**DRB Comments Response Letter:**

November 17, 2022  
City of Albuquerque  
Development Review Board

Re: **DRB Comments for PR-2022-007664**  
**Luxelocker, Luxury Boat & R.V. Storage**  
**San Diego Avenue NE, Albuquerque, NM 87113**

SHEET TITLE: **SITE PLAN**

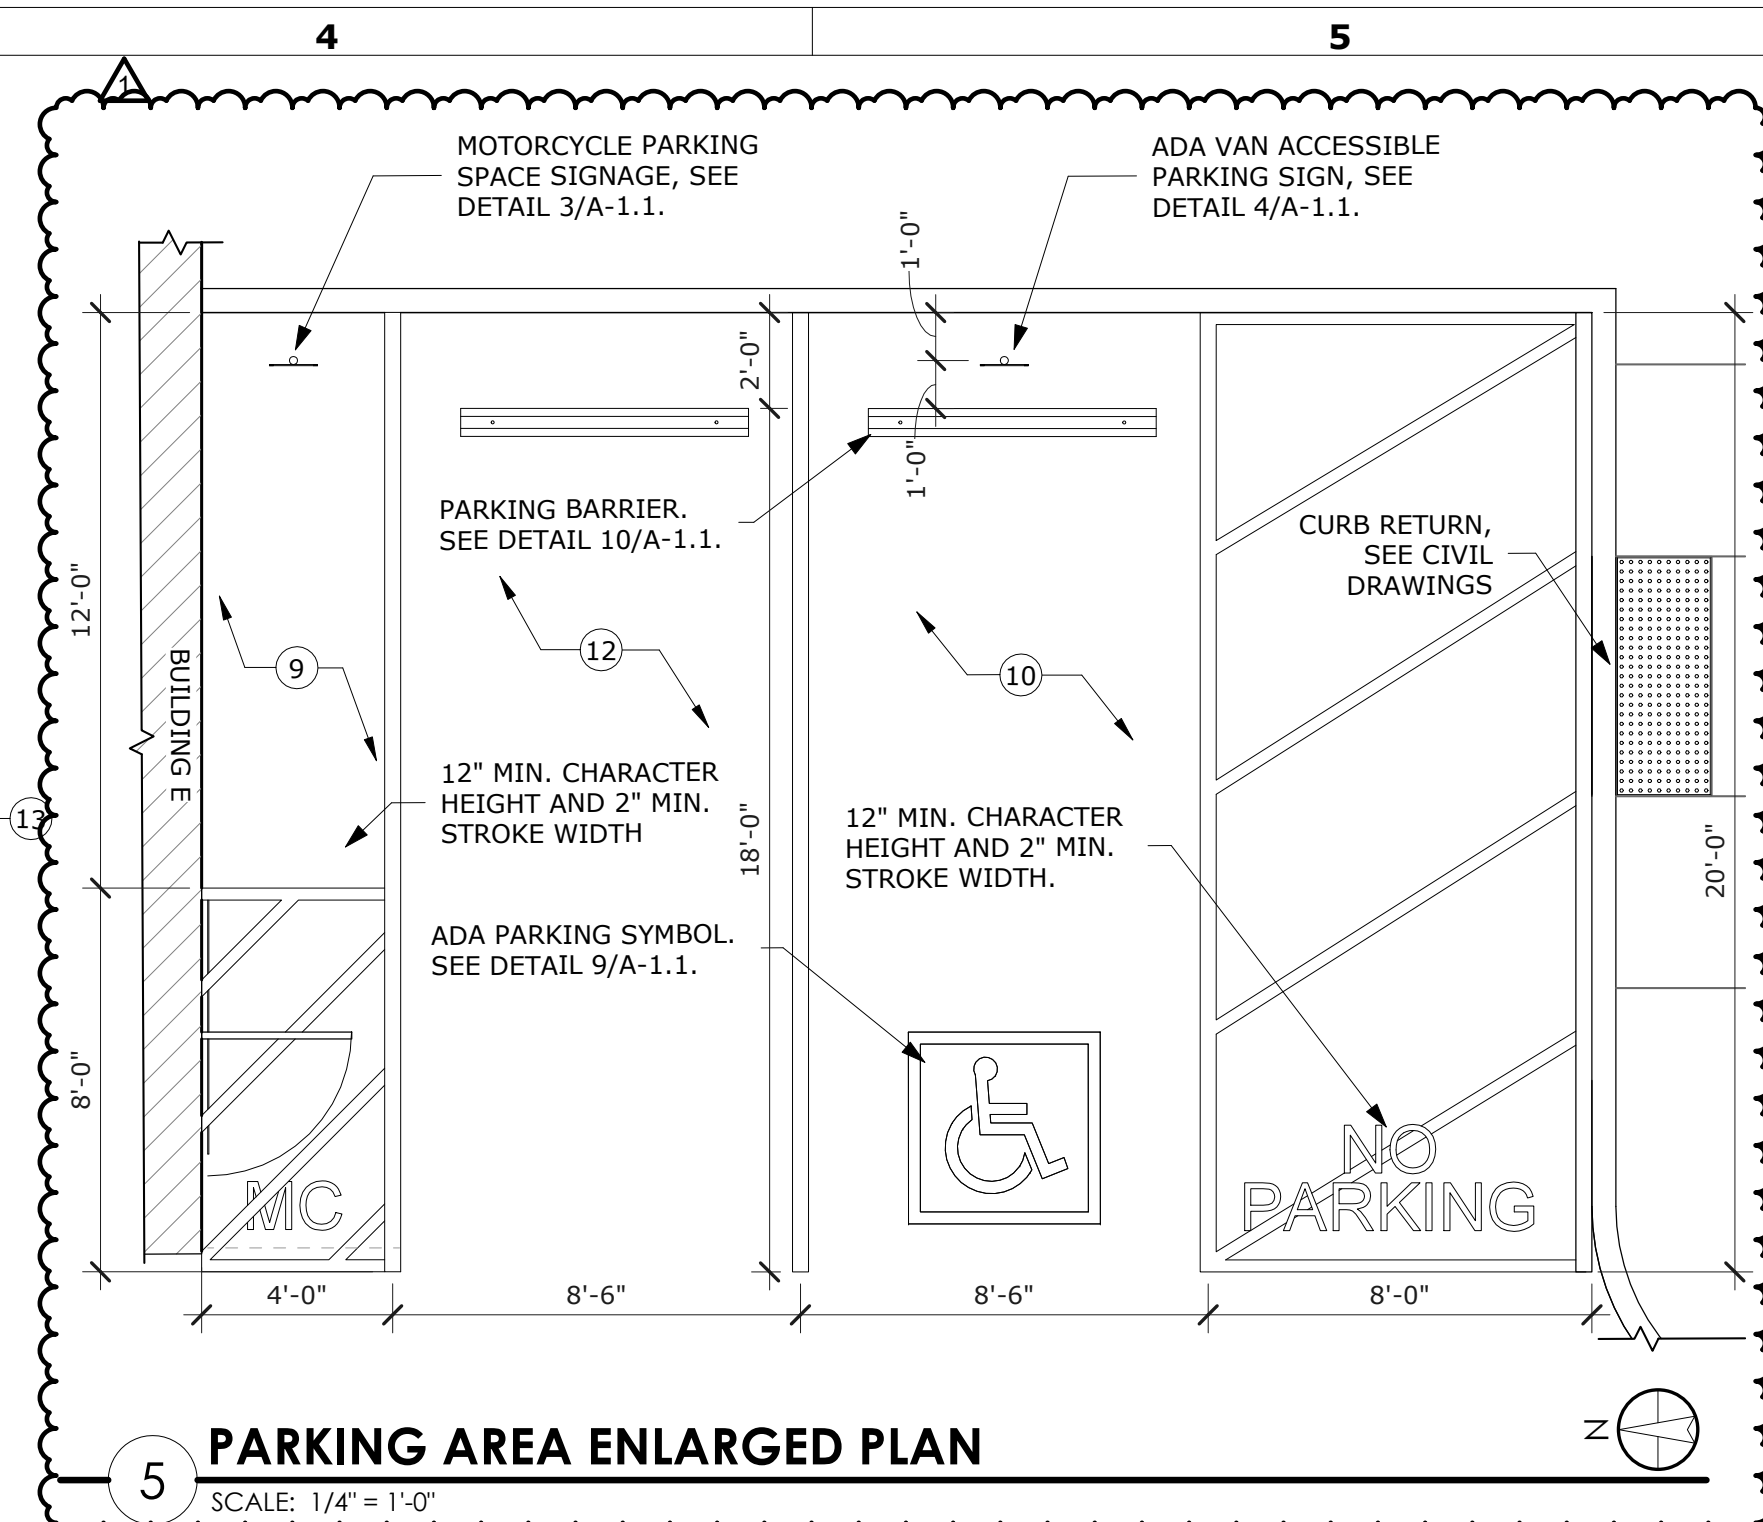
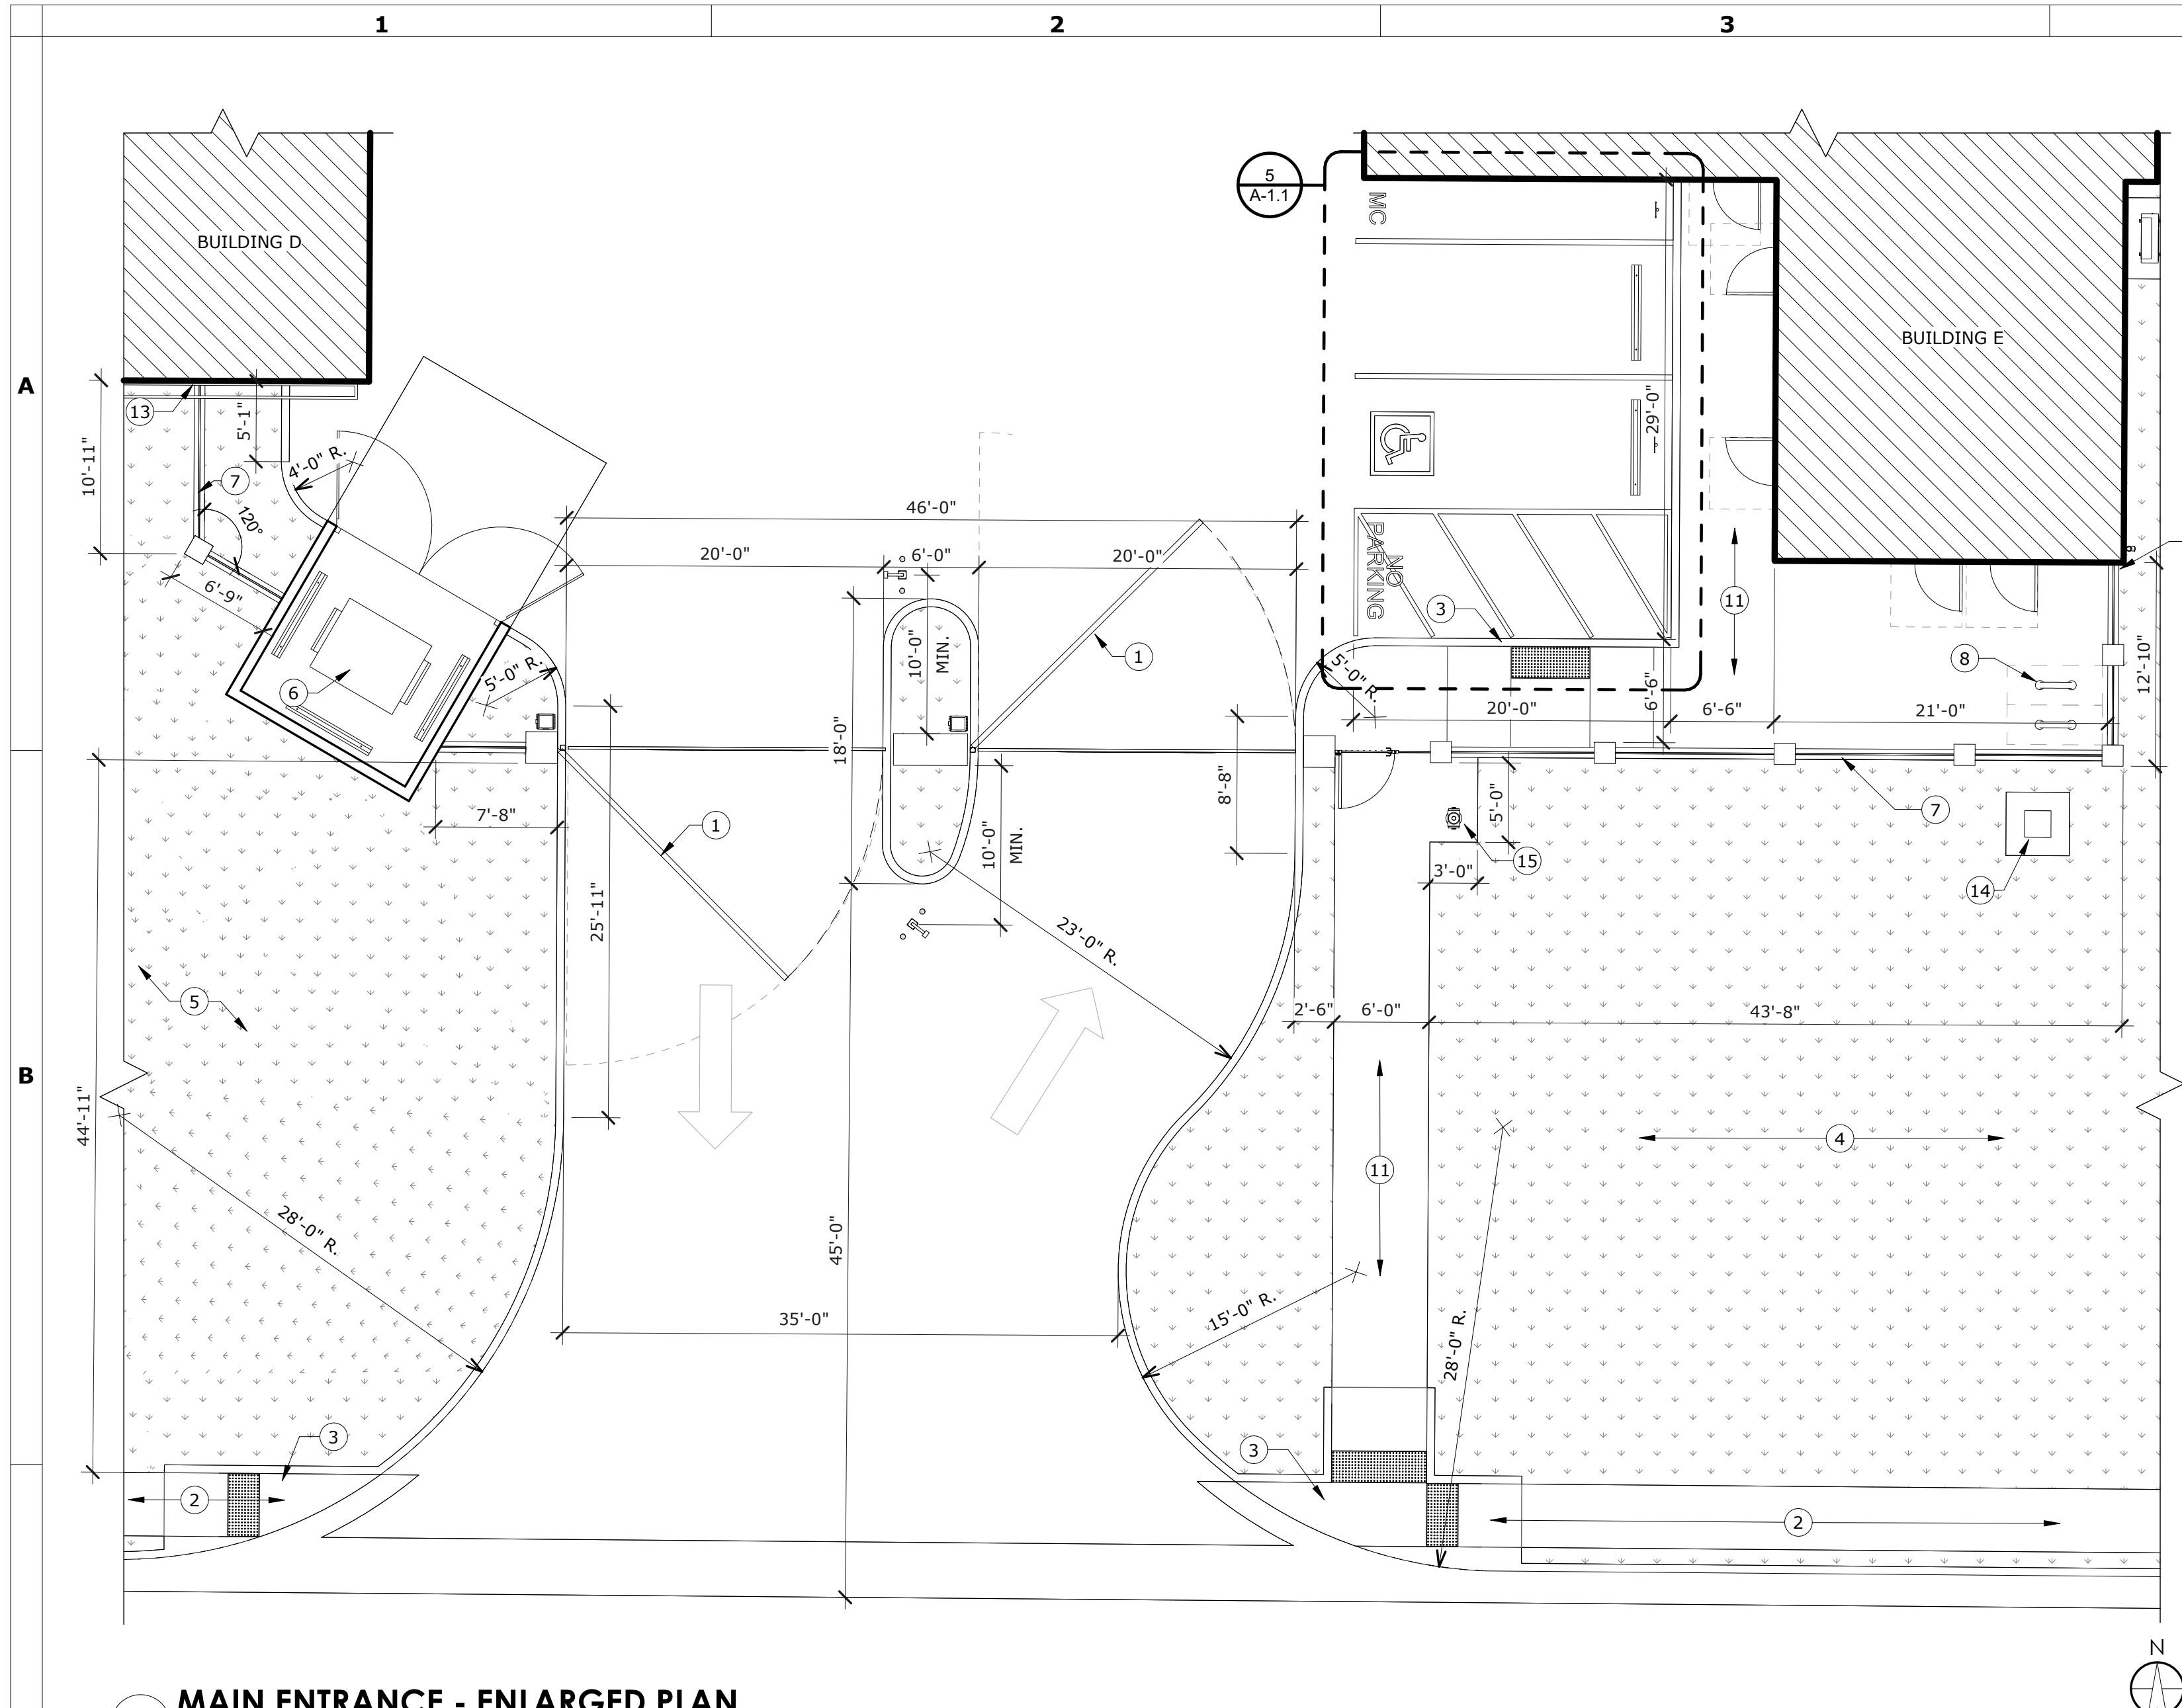
2. Show all 29 standard parking spots

8. On the Site Plan Sheet A-1.0, the parking requirements are confirmed to be met, with 29 parking spaces being provided when 29 parking spaces are required. However, it's unclear to Planning staff where the 29 parking spaces are located as Sheet A-1.0 appears to only depict a single motorcycle parking space and a single ADA parking space near the entrance to the site off of San Diego Avenue NE.

**R2. All parking spots now shown on A-1.0.**

**R8. All parking spots now shown on A-1.0.**
9. A use determination from the Zoning Enforcement Official may be needed to clarify parking and use specific standards that would apply.

SHEET NUMBER
A-4.0

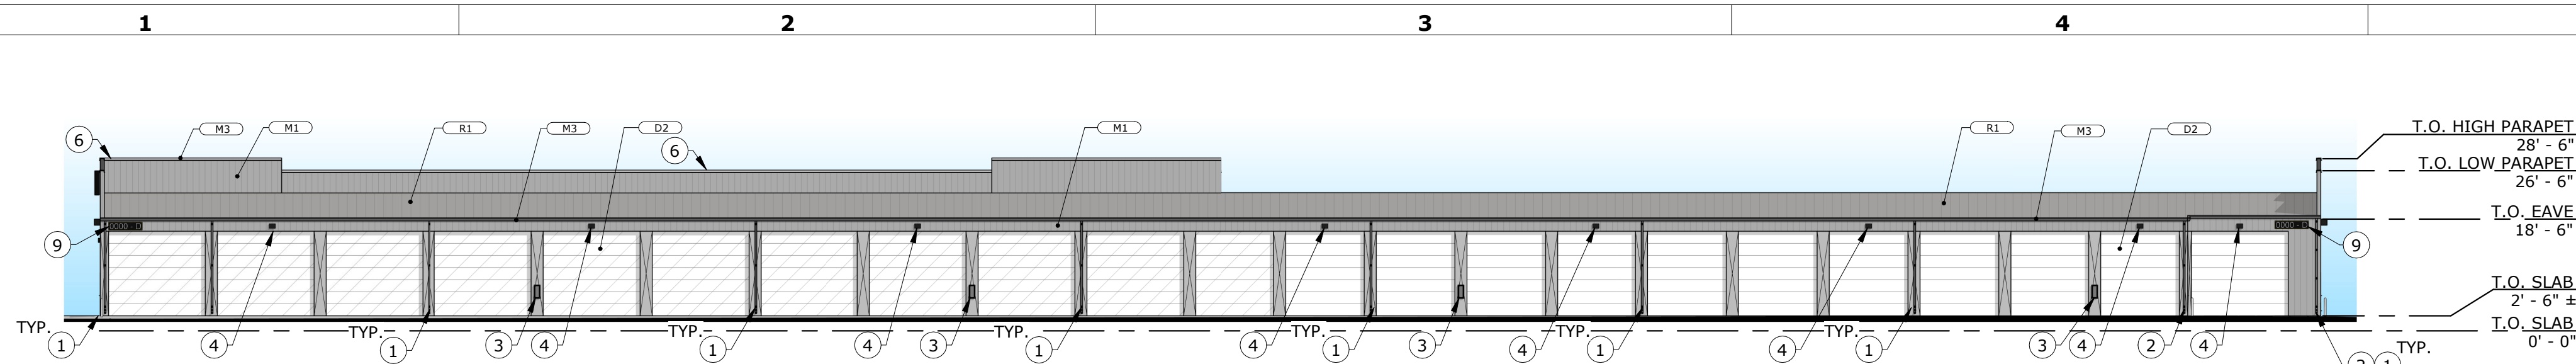
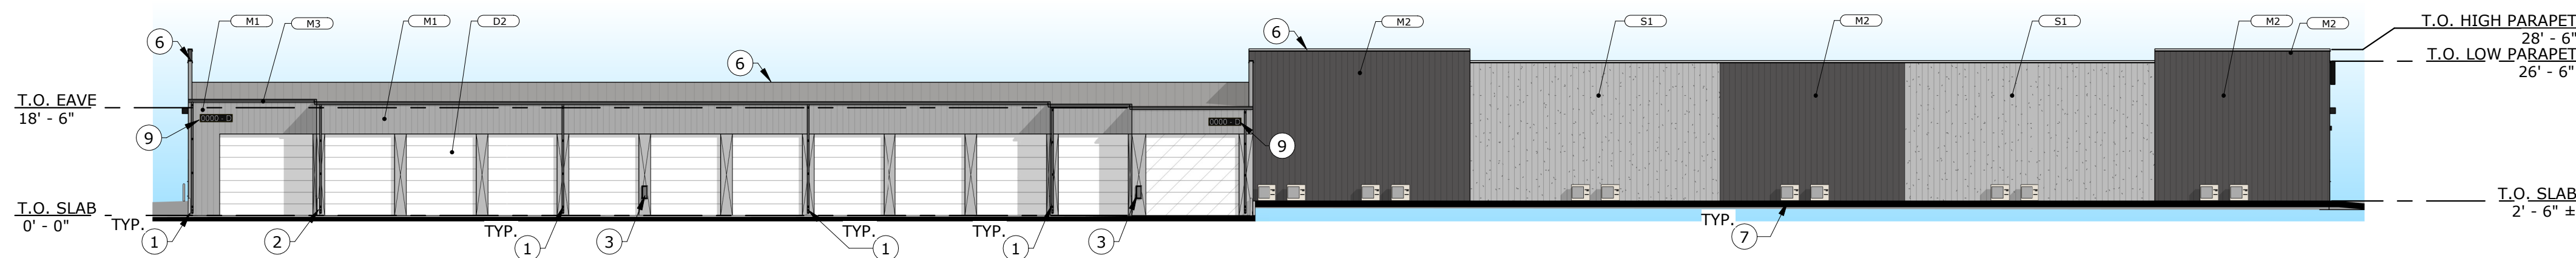
**R5. Confirmed.**
6. The site is in the North I-25 Character Protection Overlay (CPO-10). The following provisions of IDO 3-4 apply:
  - a. Maximum building height of 52 feet.

**R6a. Please see proposed building height on sheet A-1.0 and exterior elevation sheets A-4.0 & A-4.1. Max proposed building height is 26'-0" which conforms to IDO 3-4(K)(3)(b).**
